Dean Moor Solar Farm

Applicant Response to Local Impact Report

30 September 2025
Prepared by: Broadfield
PINS Ref: EN010155
Document Ref: D3.7
Deadline: 3
Revision: 1

DEAN MOOR SOLAR FARM
APPLICANT RESPONSE TO CUMBERLAND COUNCIL'S
LOCAL IMPACT REPORT
PLANNING INSPECTORATE REFERENCE EN010155
PREPARED ON BEHALF OF FVS DEAN MOOR LIMITED

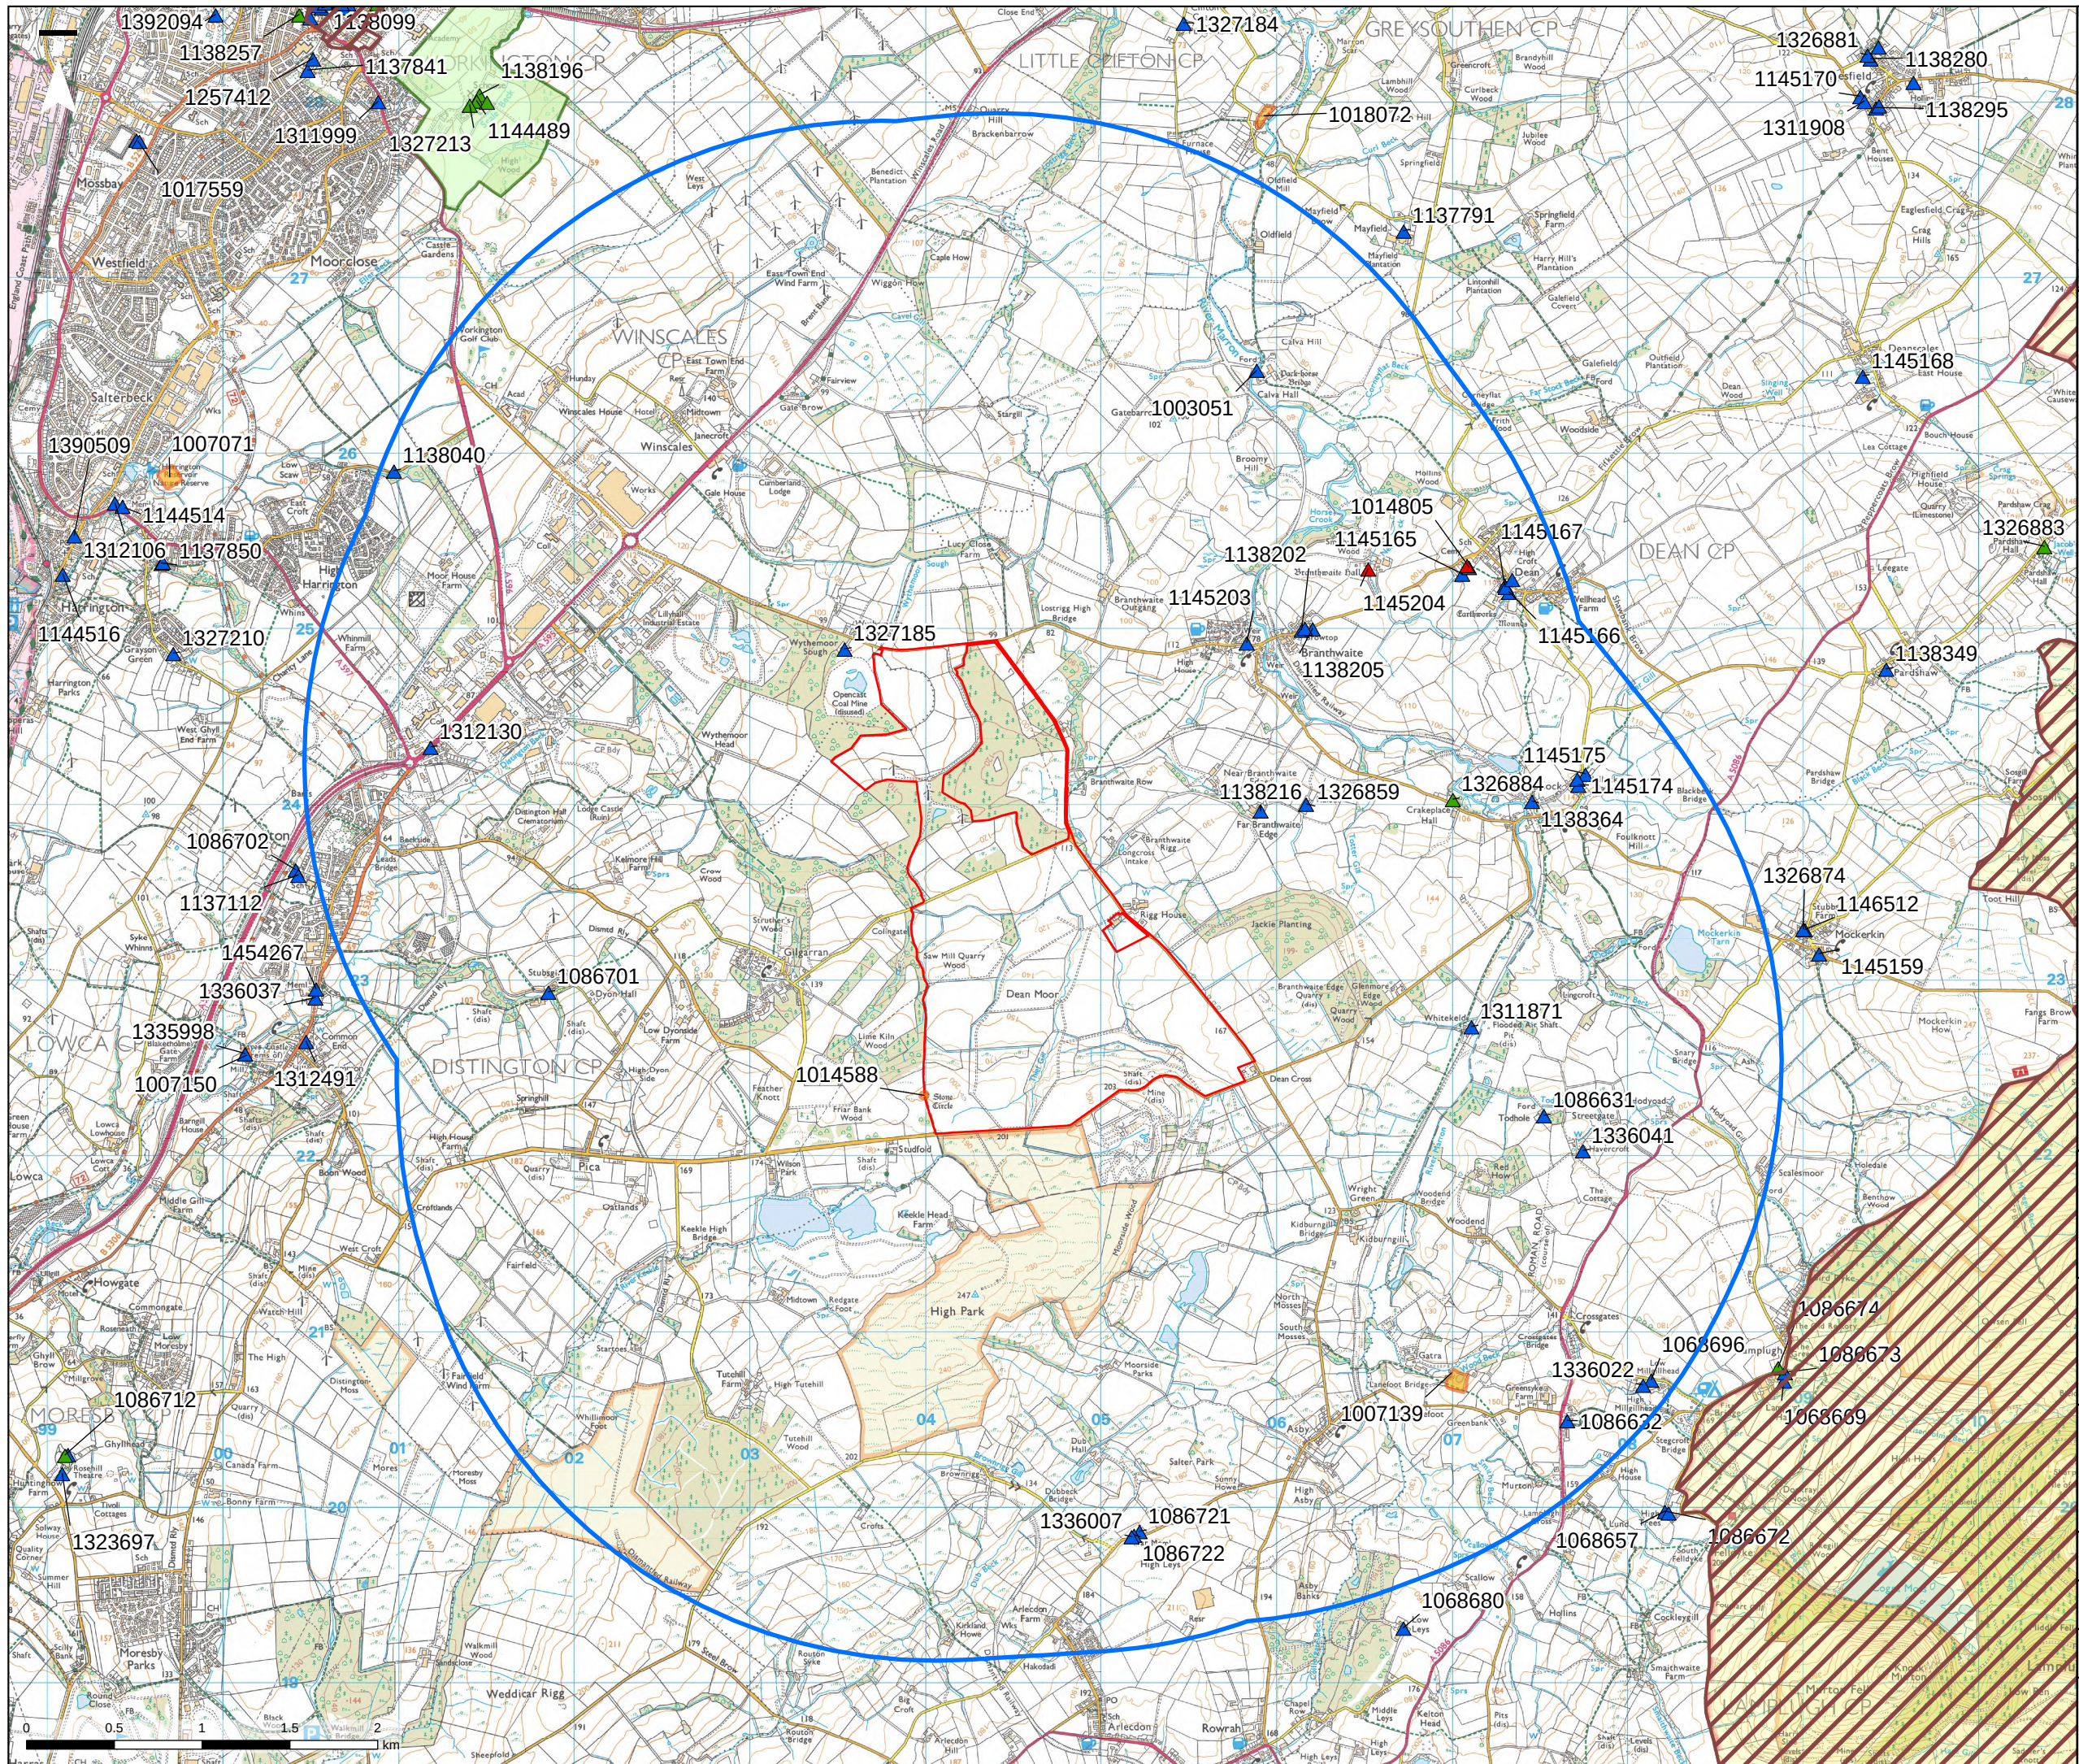
10.6	<i>The Study Area comprising the land within the Site and a 3km buffer from the Site boundary used to assess designated heritage receptors (as shown in ES Figure 6.1) is accepted. It is noted that the Scoping Report for the Proposed Development (Appendix 2.1) included proposed methodologies for assessing archaeology and built heritage in the ES. The Planning Inspectorate's Scoping Opinion (Appendix 2.2) identified further receptors to be considered for determining 'significant' effects and these have been considered. The Zone of theoretical visibility (ZTV) for the Proposed Development is shown in Figure 6.3 and for the purpose of assessing Cultural Heritage this is accepted. A series of ZTV analysis has been undertaken based upon the design parameters that are listed in Chapter 3 – Site and Development Description [REF: 6.1]. The ZTV calculation is performed using particular geographic information systems ('GIS') software (ESRI ArcGIS Pro 3.0.2) under the Viewshed Spatial Analyst tool.</i>	It is noted that the Council accept the Study Area and Zone of Theoretical Visibility for ES Chapter 6 Cultural Heritage to assess designated heritage receptors. The Cumberland Council dSoCG [D3.14] has been updated accordingly.

ES Figure 2.1 Cumulative Schemes within 10km of Order Limits

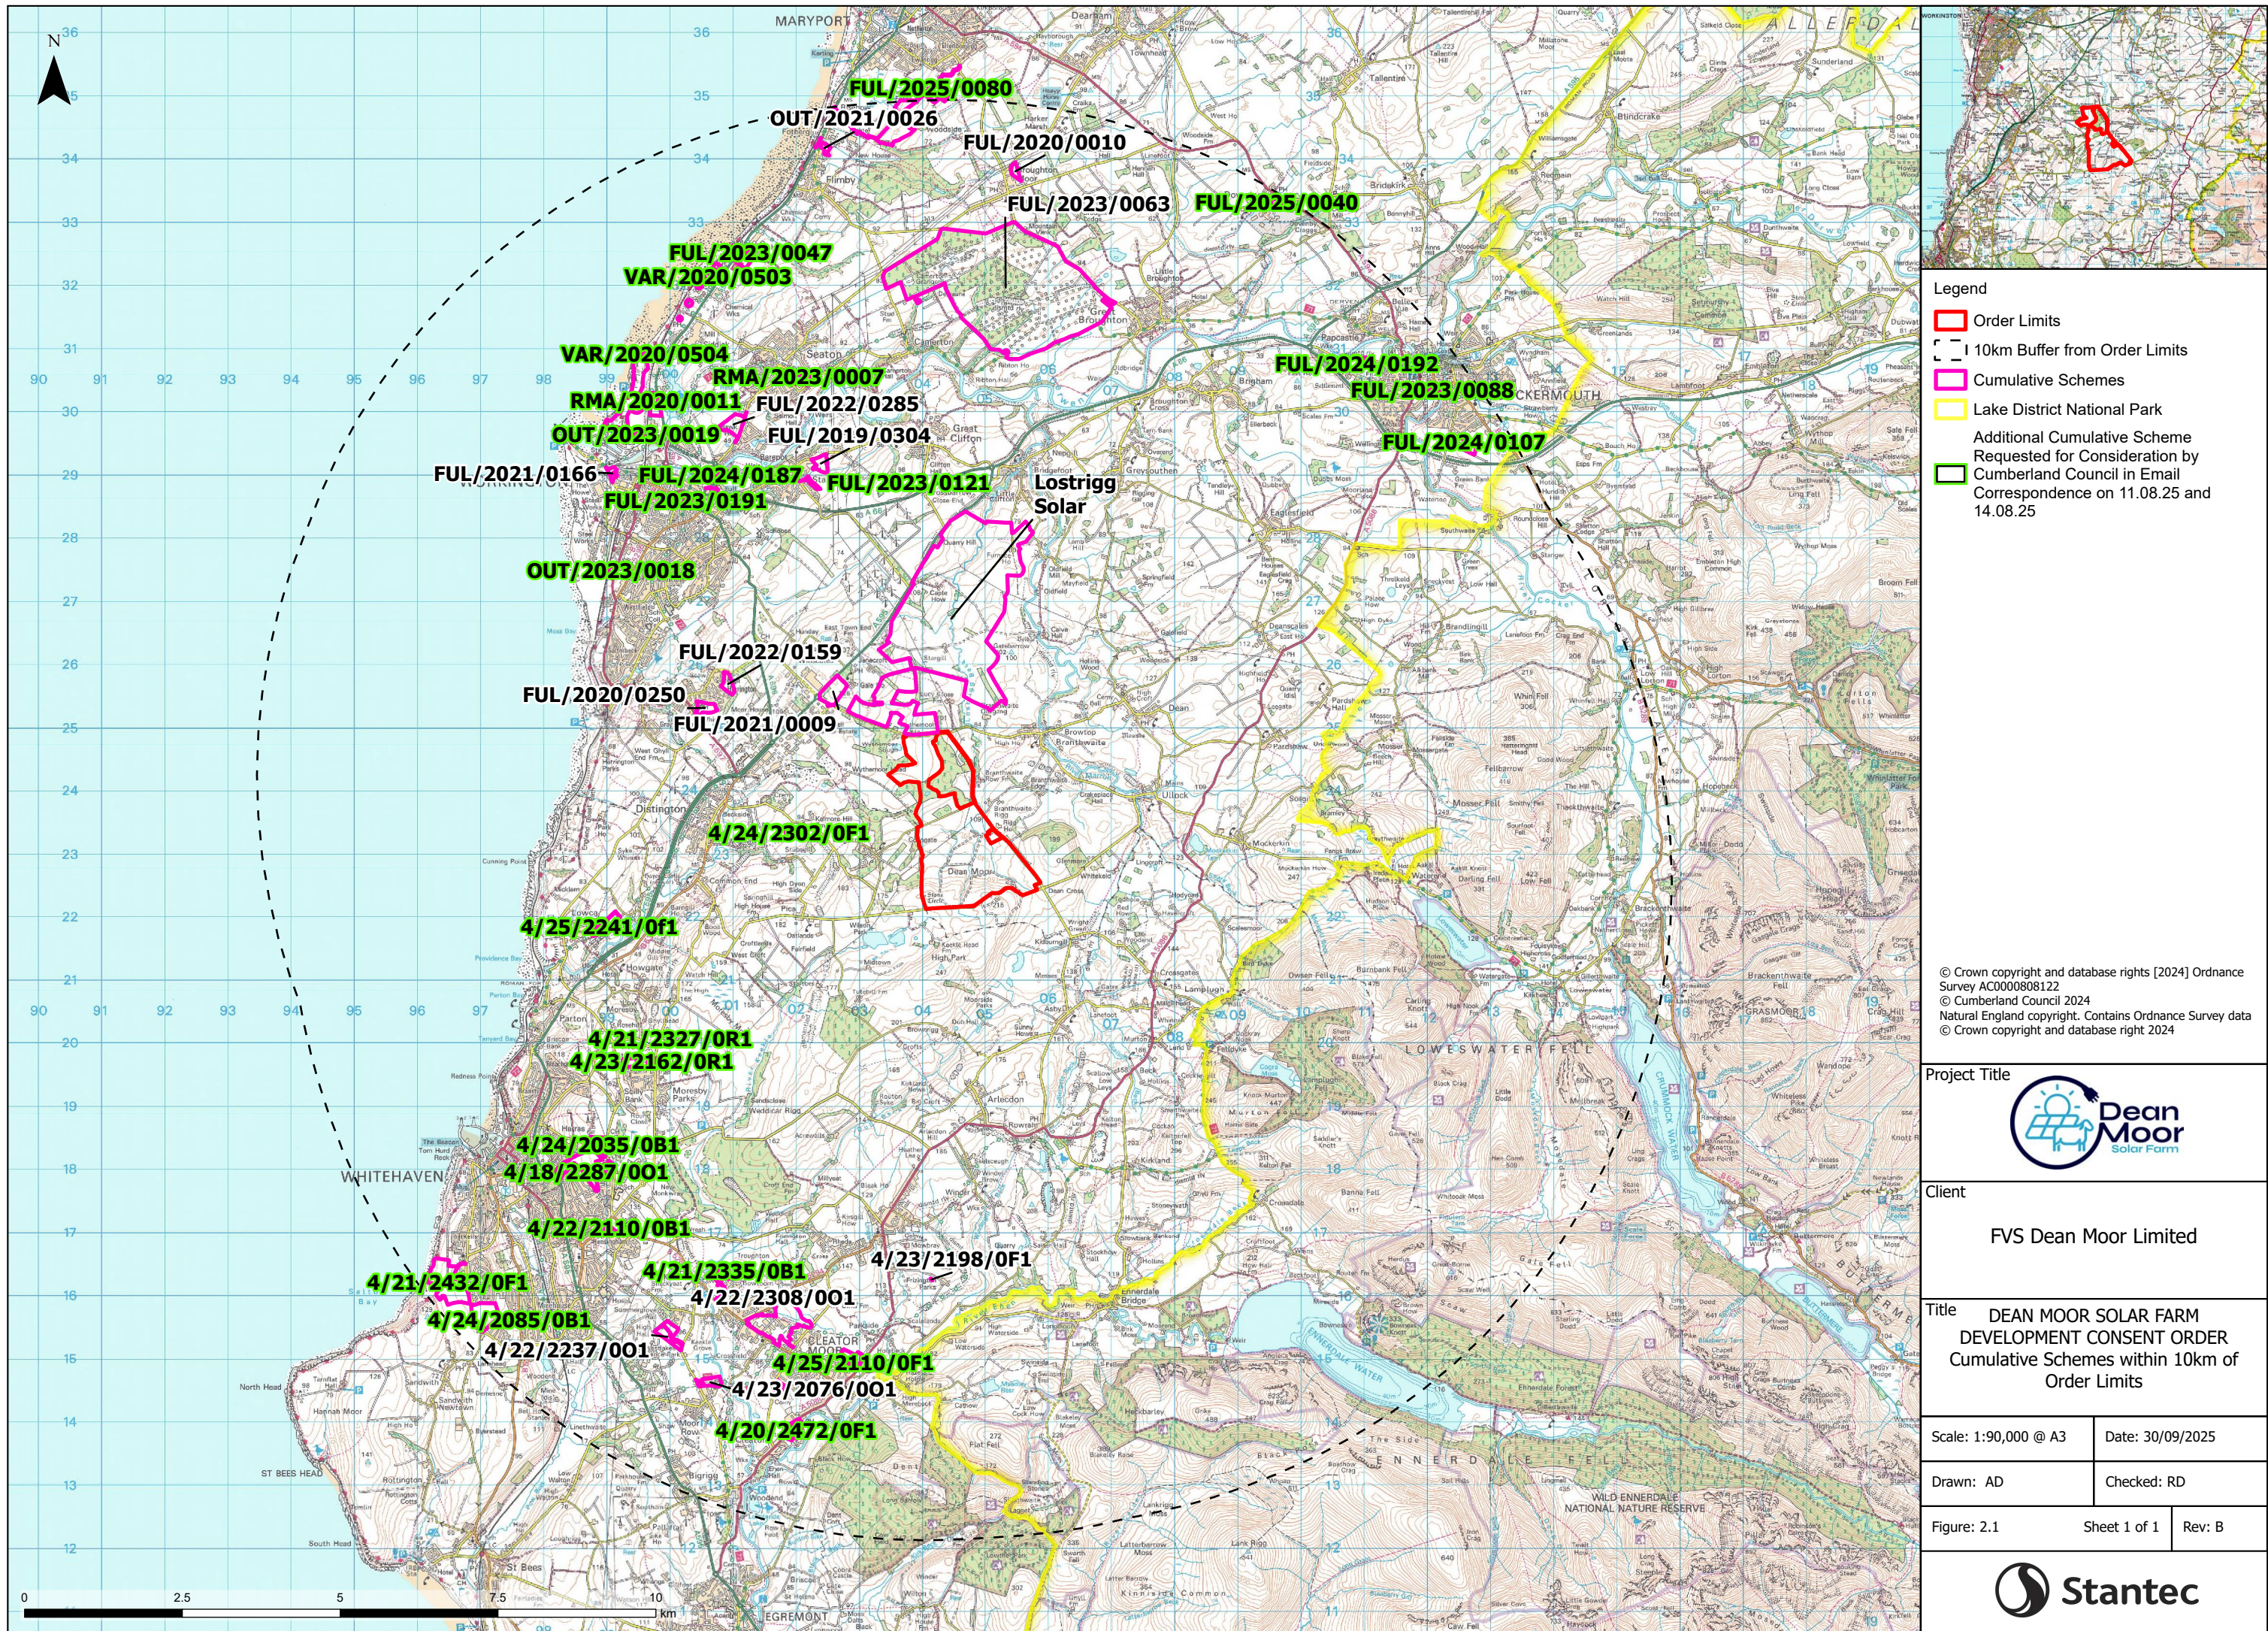
Ref	Matter Raised	Applicant Response
5.1	<i>List of Cumulative Schemes is set out in ES Table 2.6 Cumulative Schemes. The Council has since supplied an updated list of sites which is currently being reviewed by the Applicant</i>	The Applicant received a list of 31 additional schemes from the Council in August 2025 and has undertaken a proportionate cumulative assessment of these schemes for each EIA topic. A Cumulative Assessment Note which considers these schemes is included at Appendix A of this ARLIR which is supported by a revision to ES Figure 2.1 Cumulative Schemes within 10km of Order Limits (formerly APP-044 , now D3.17)
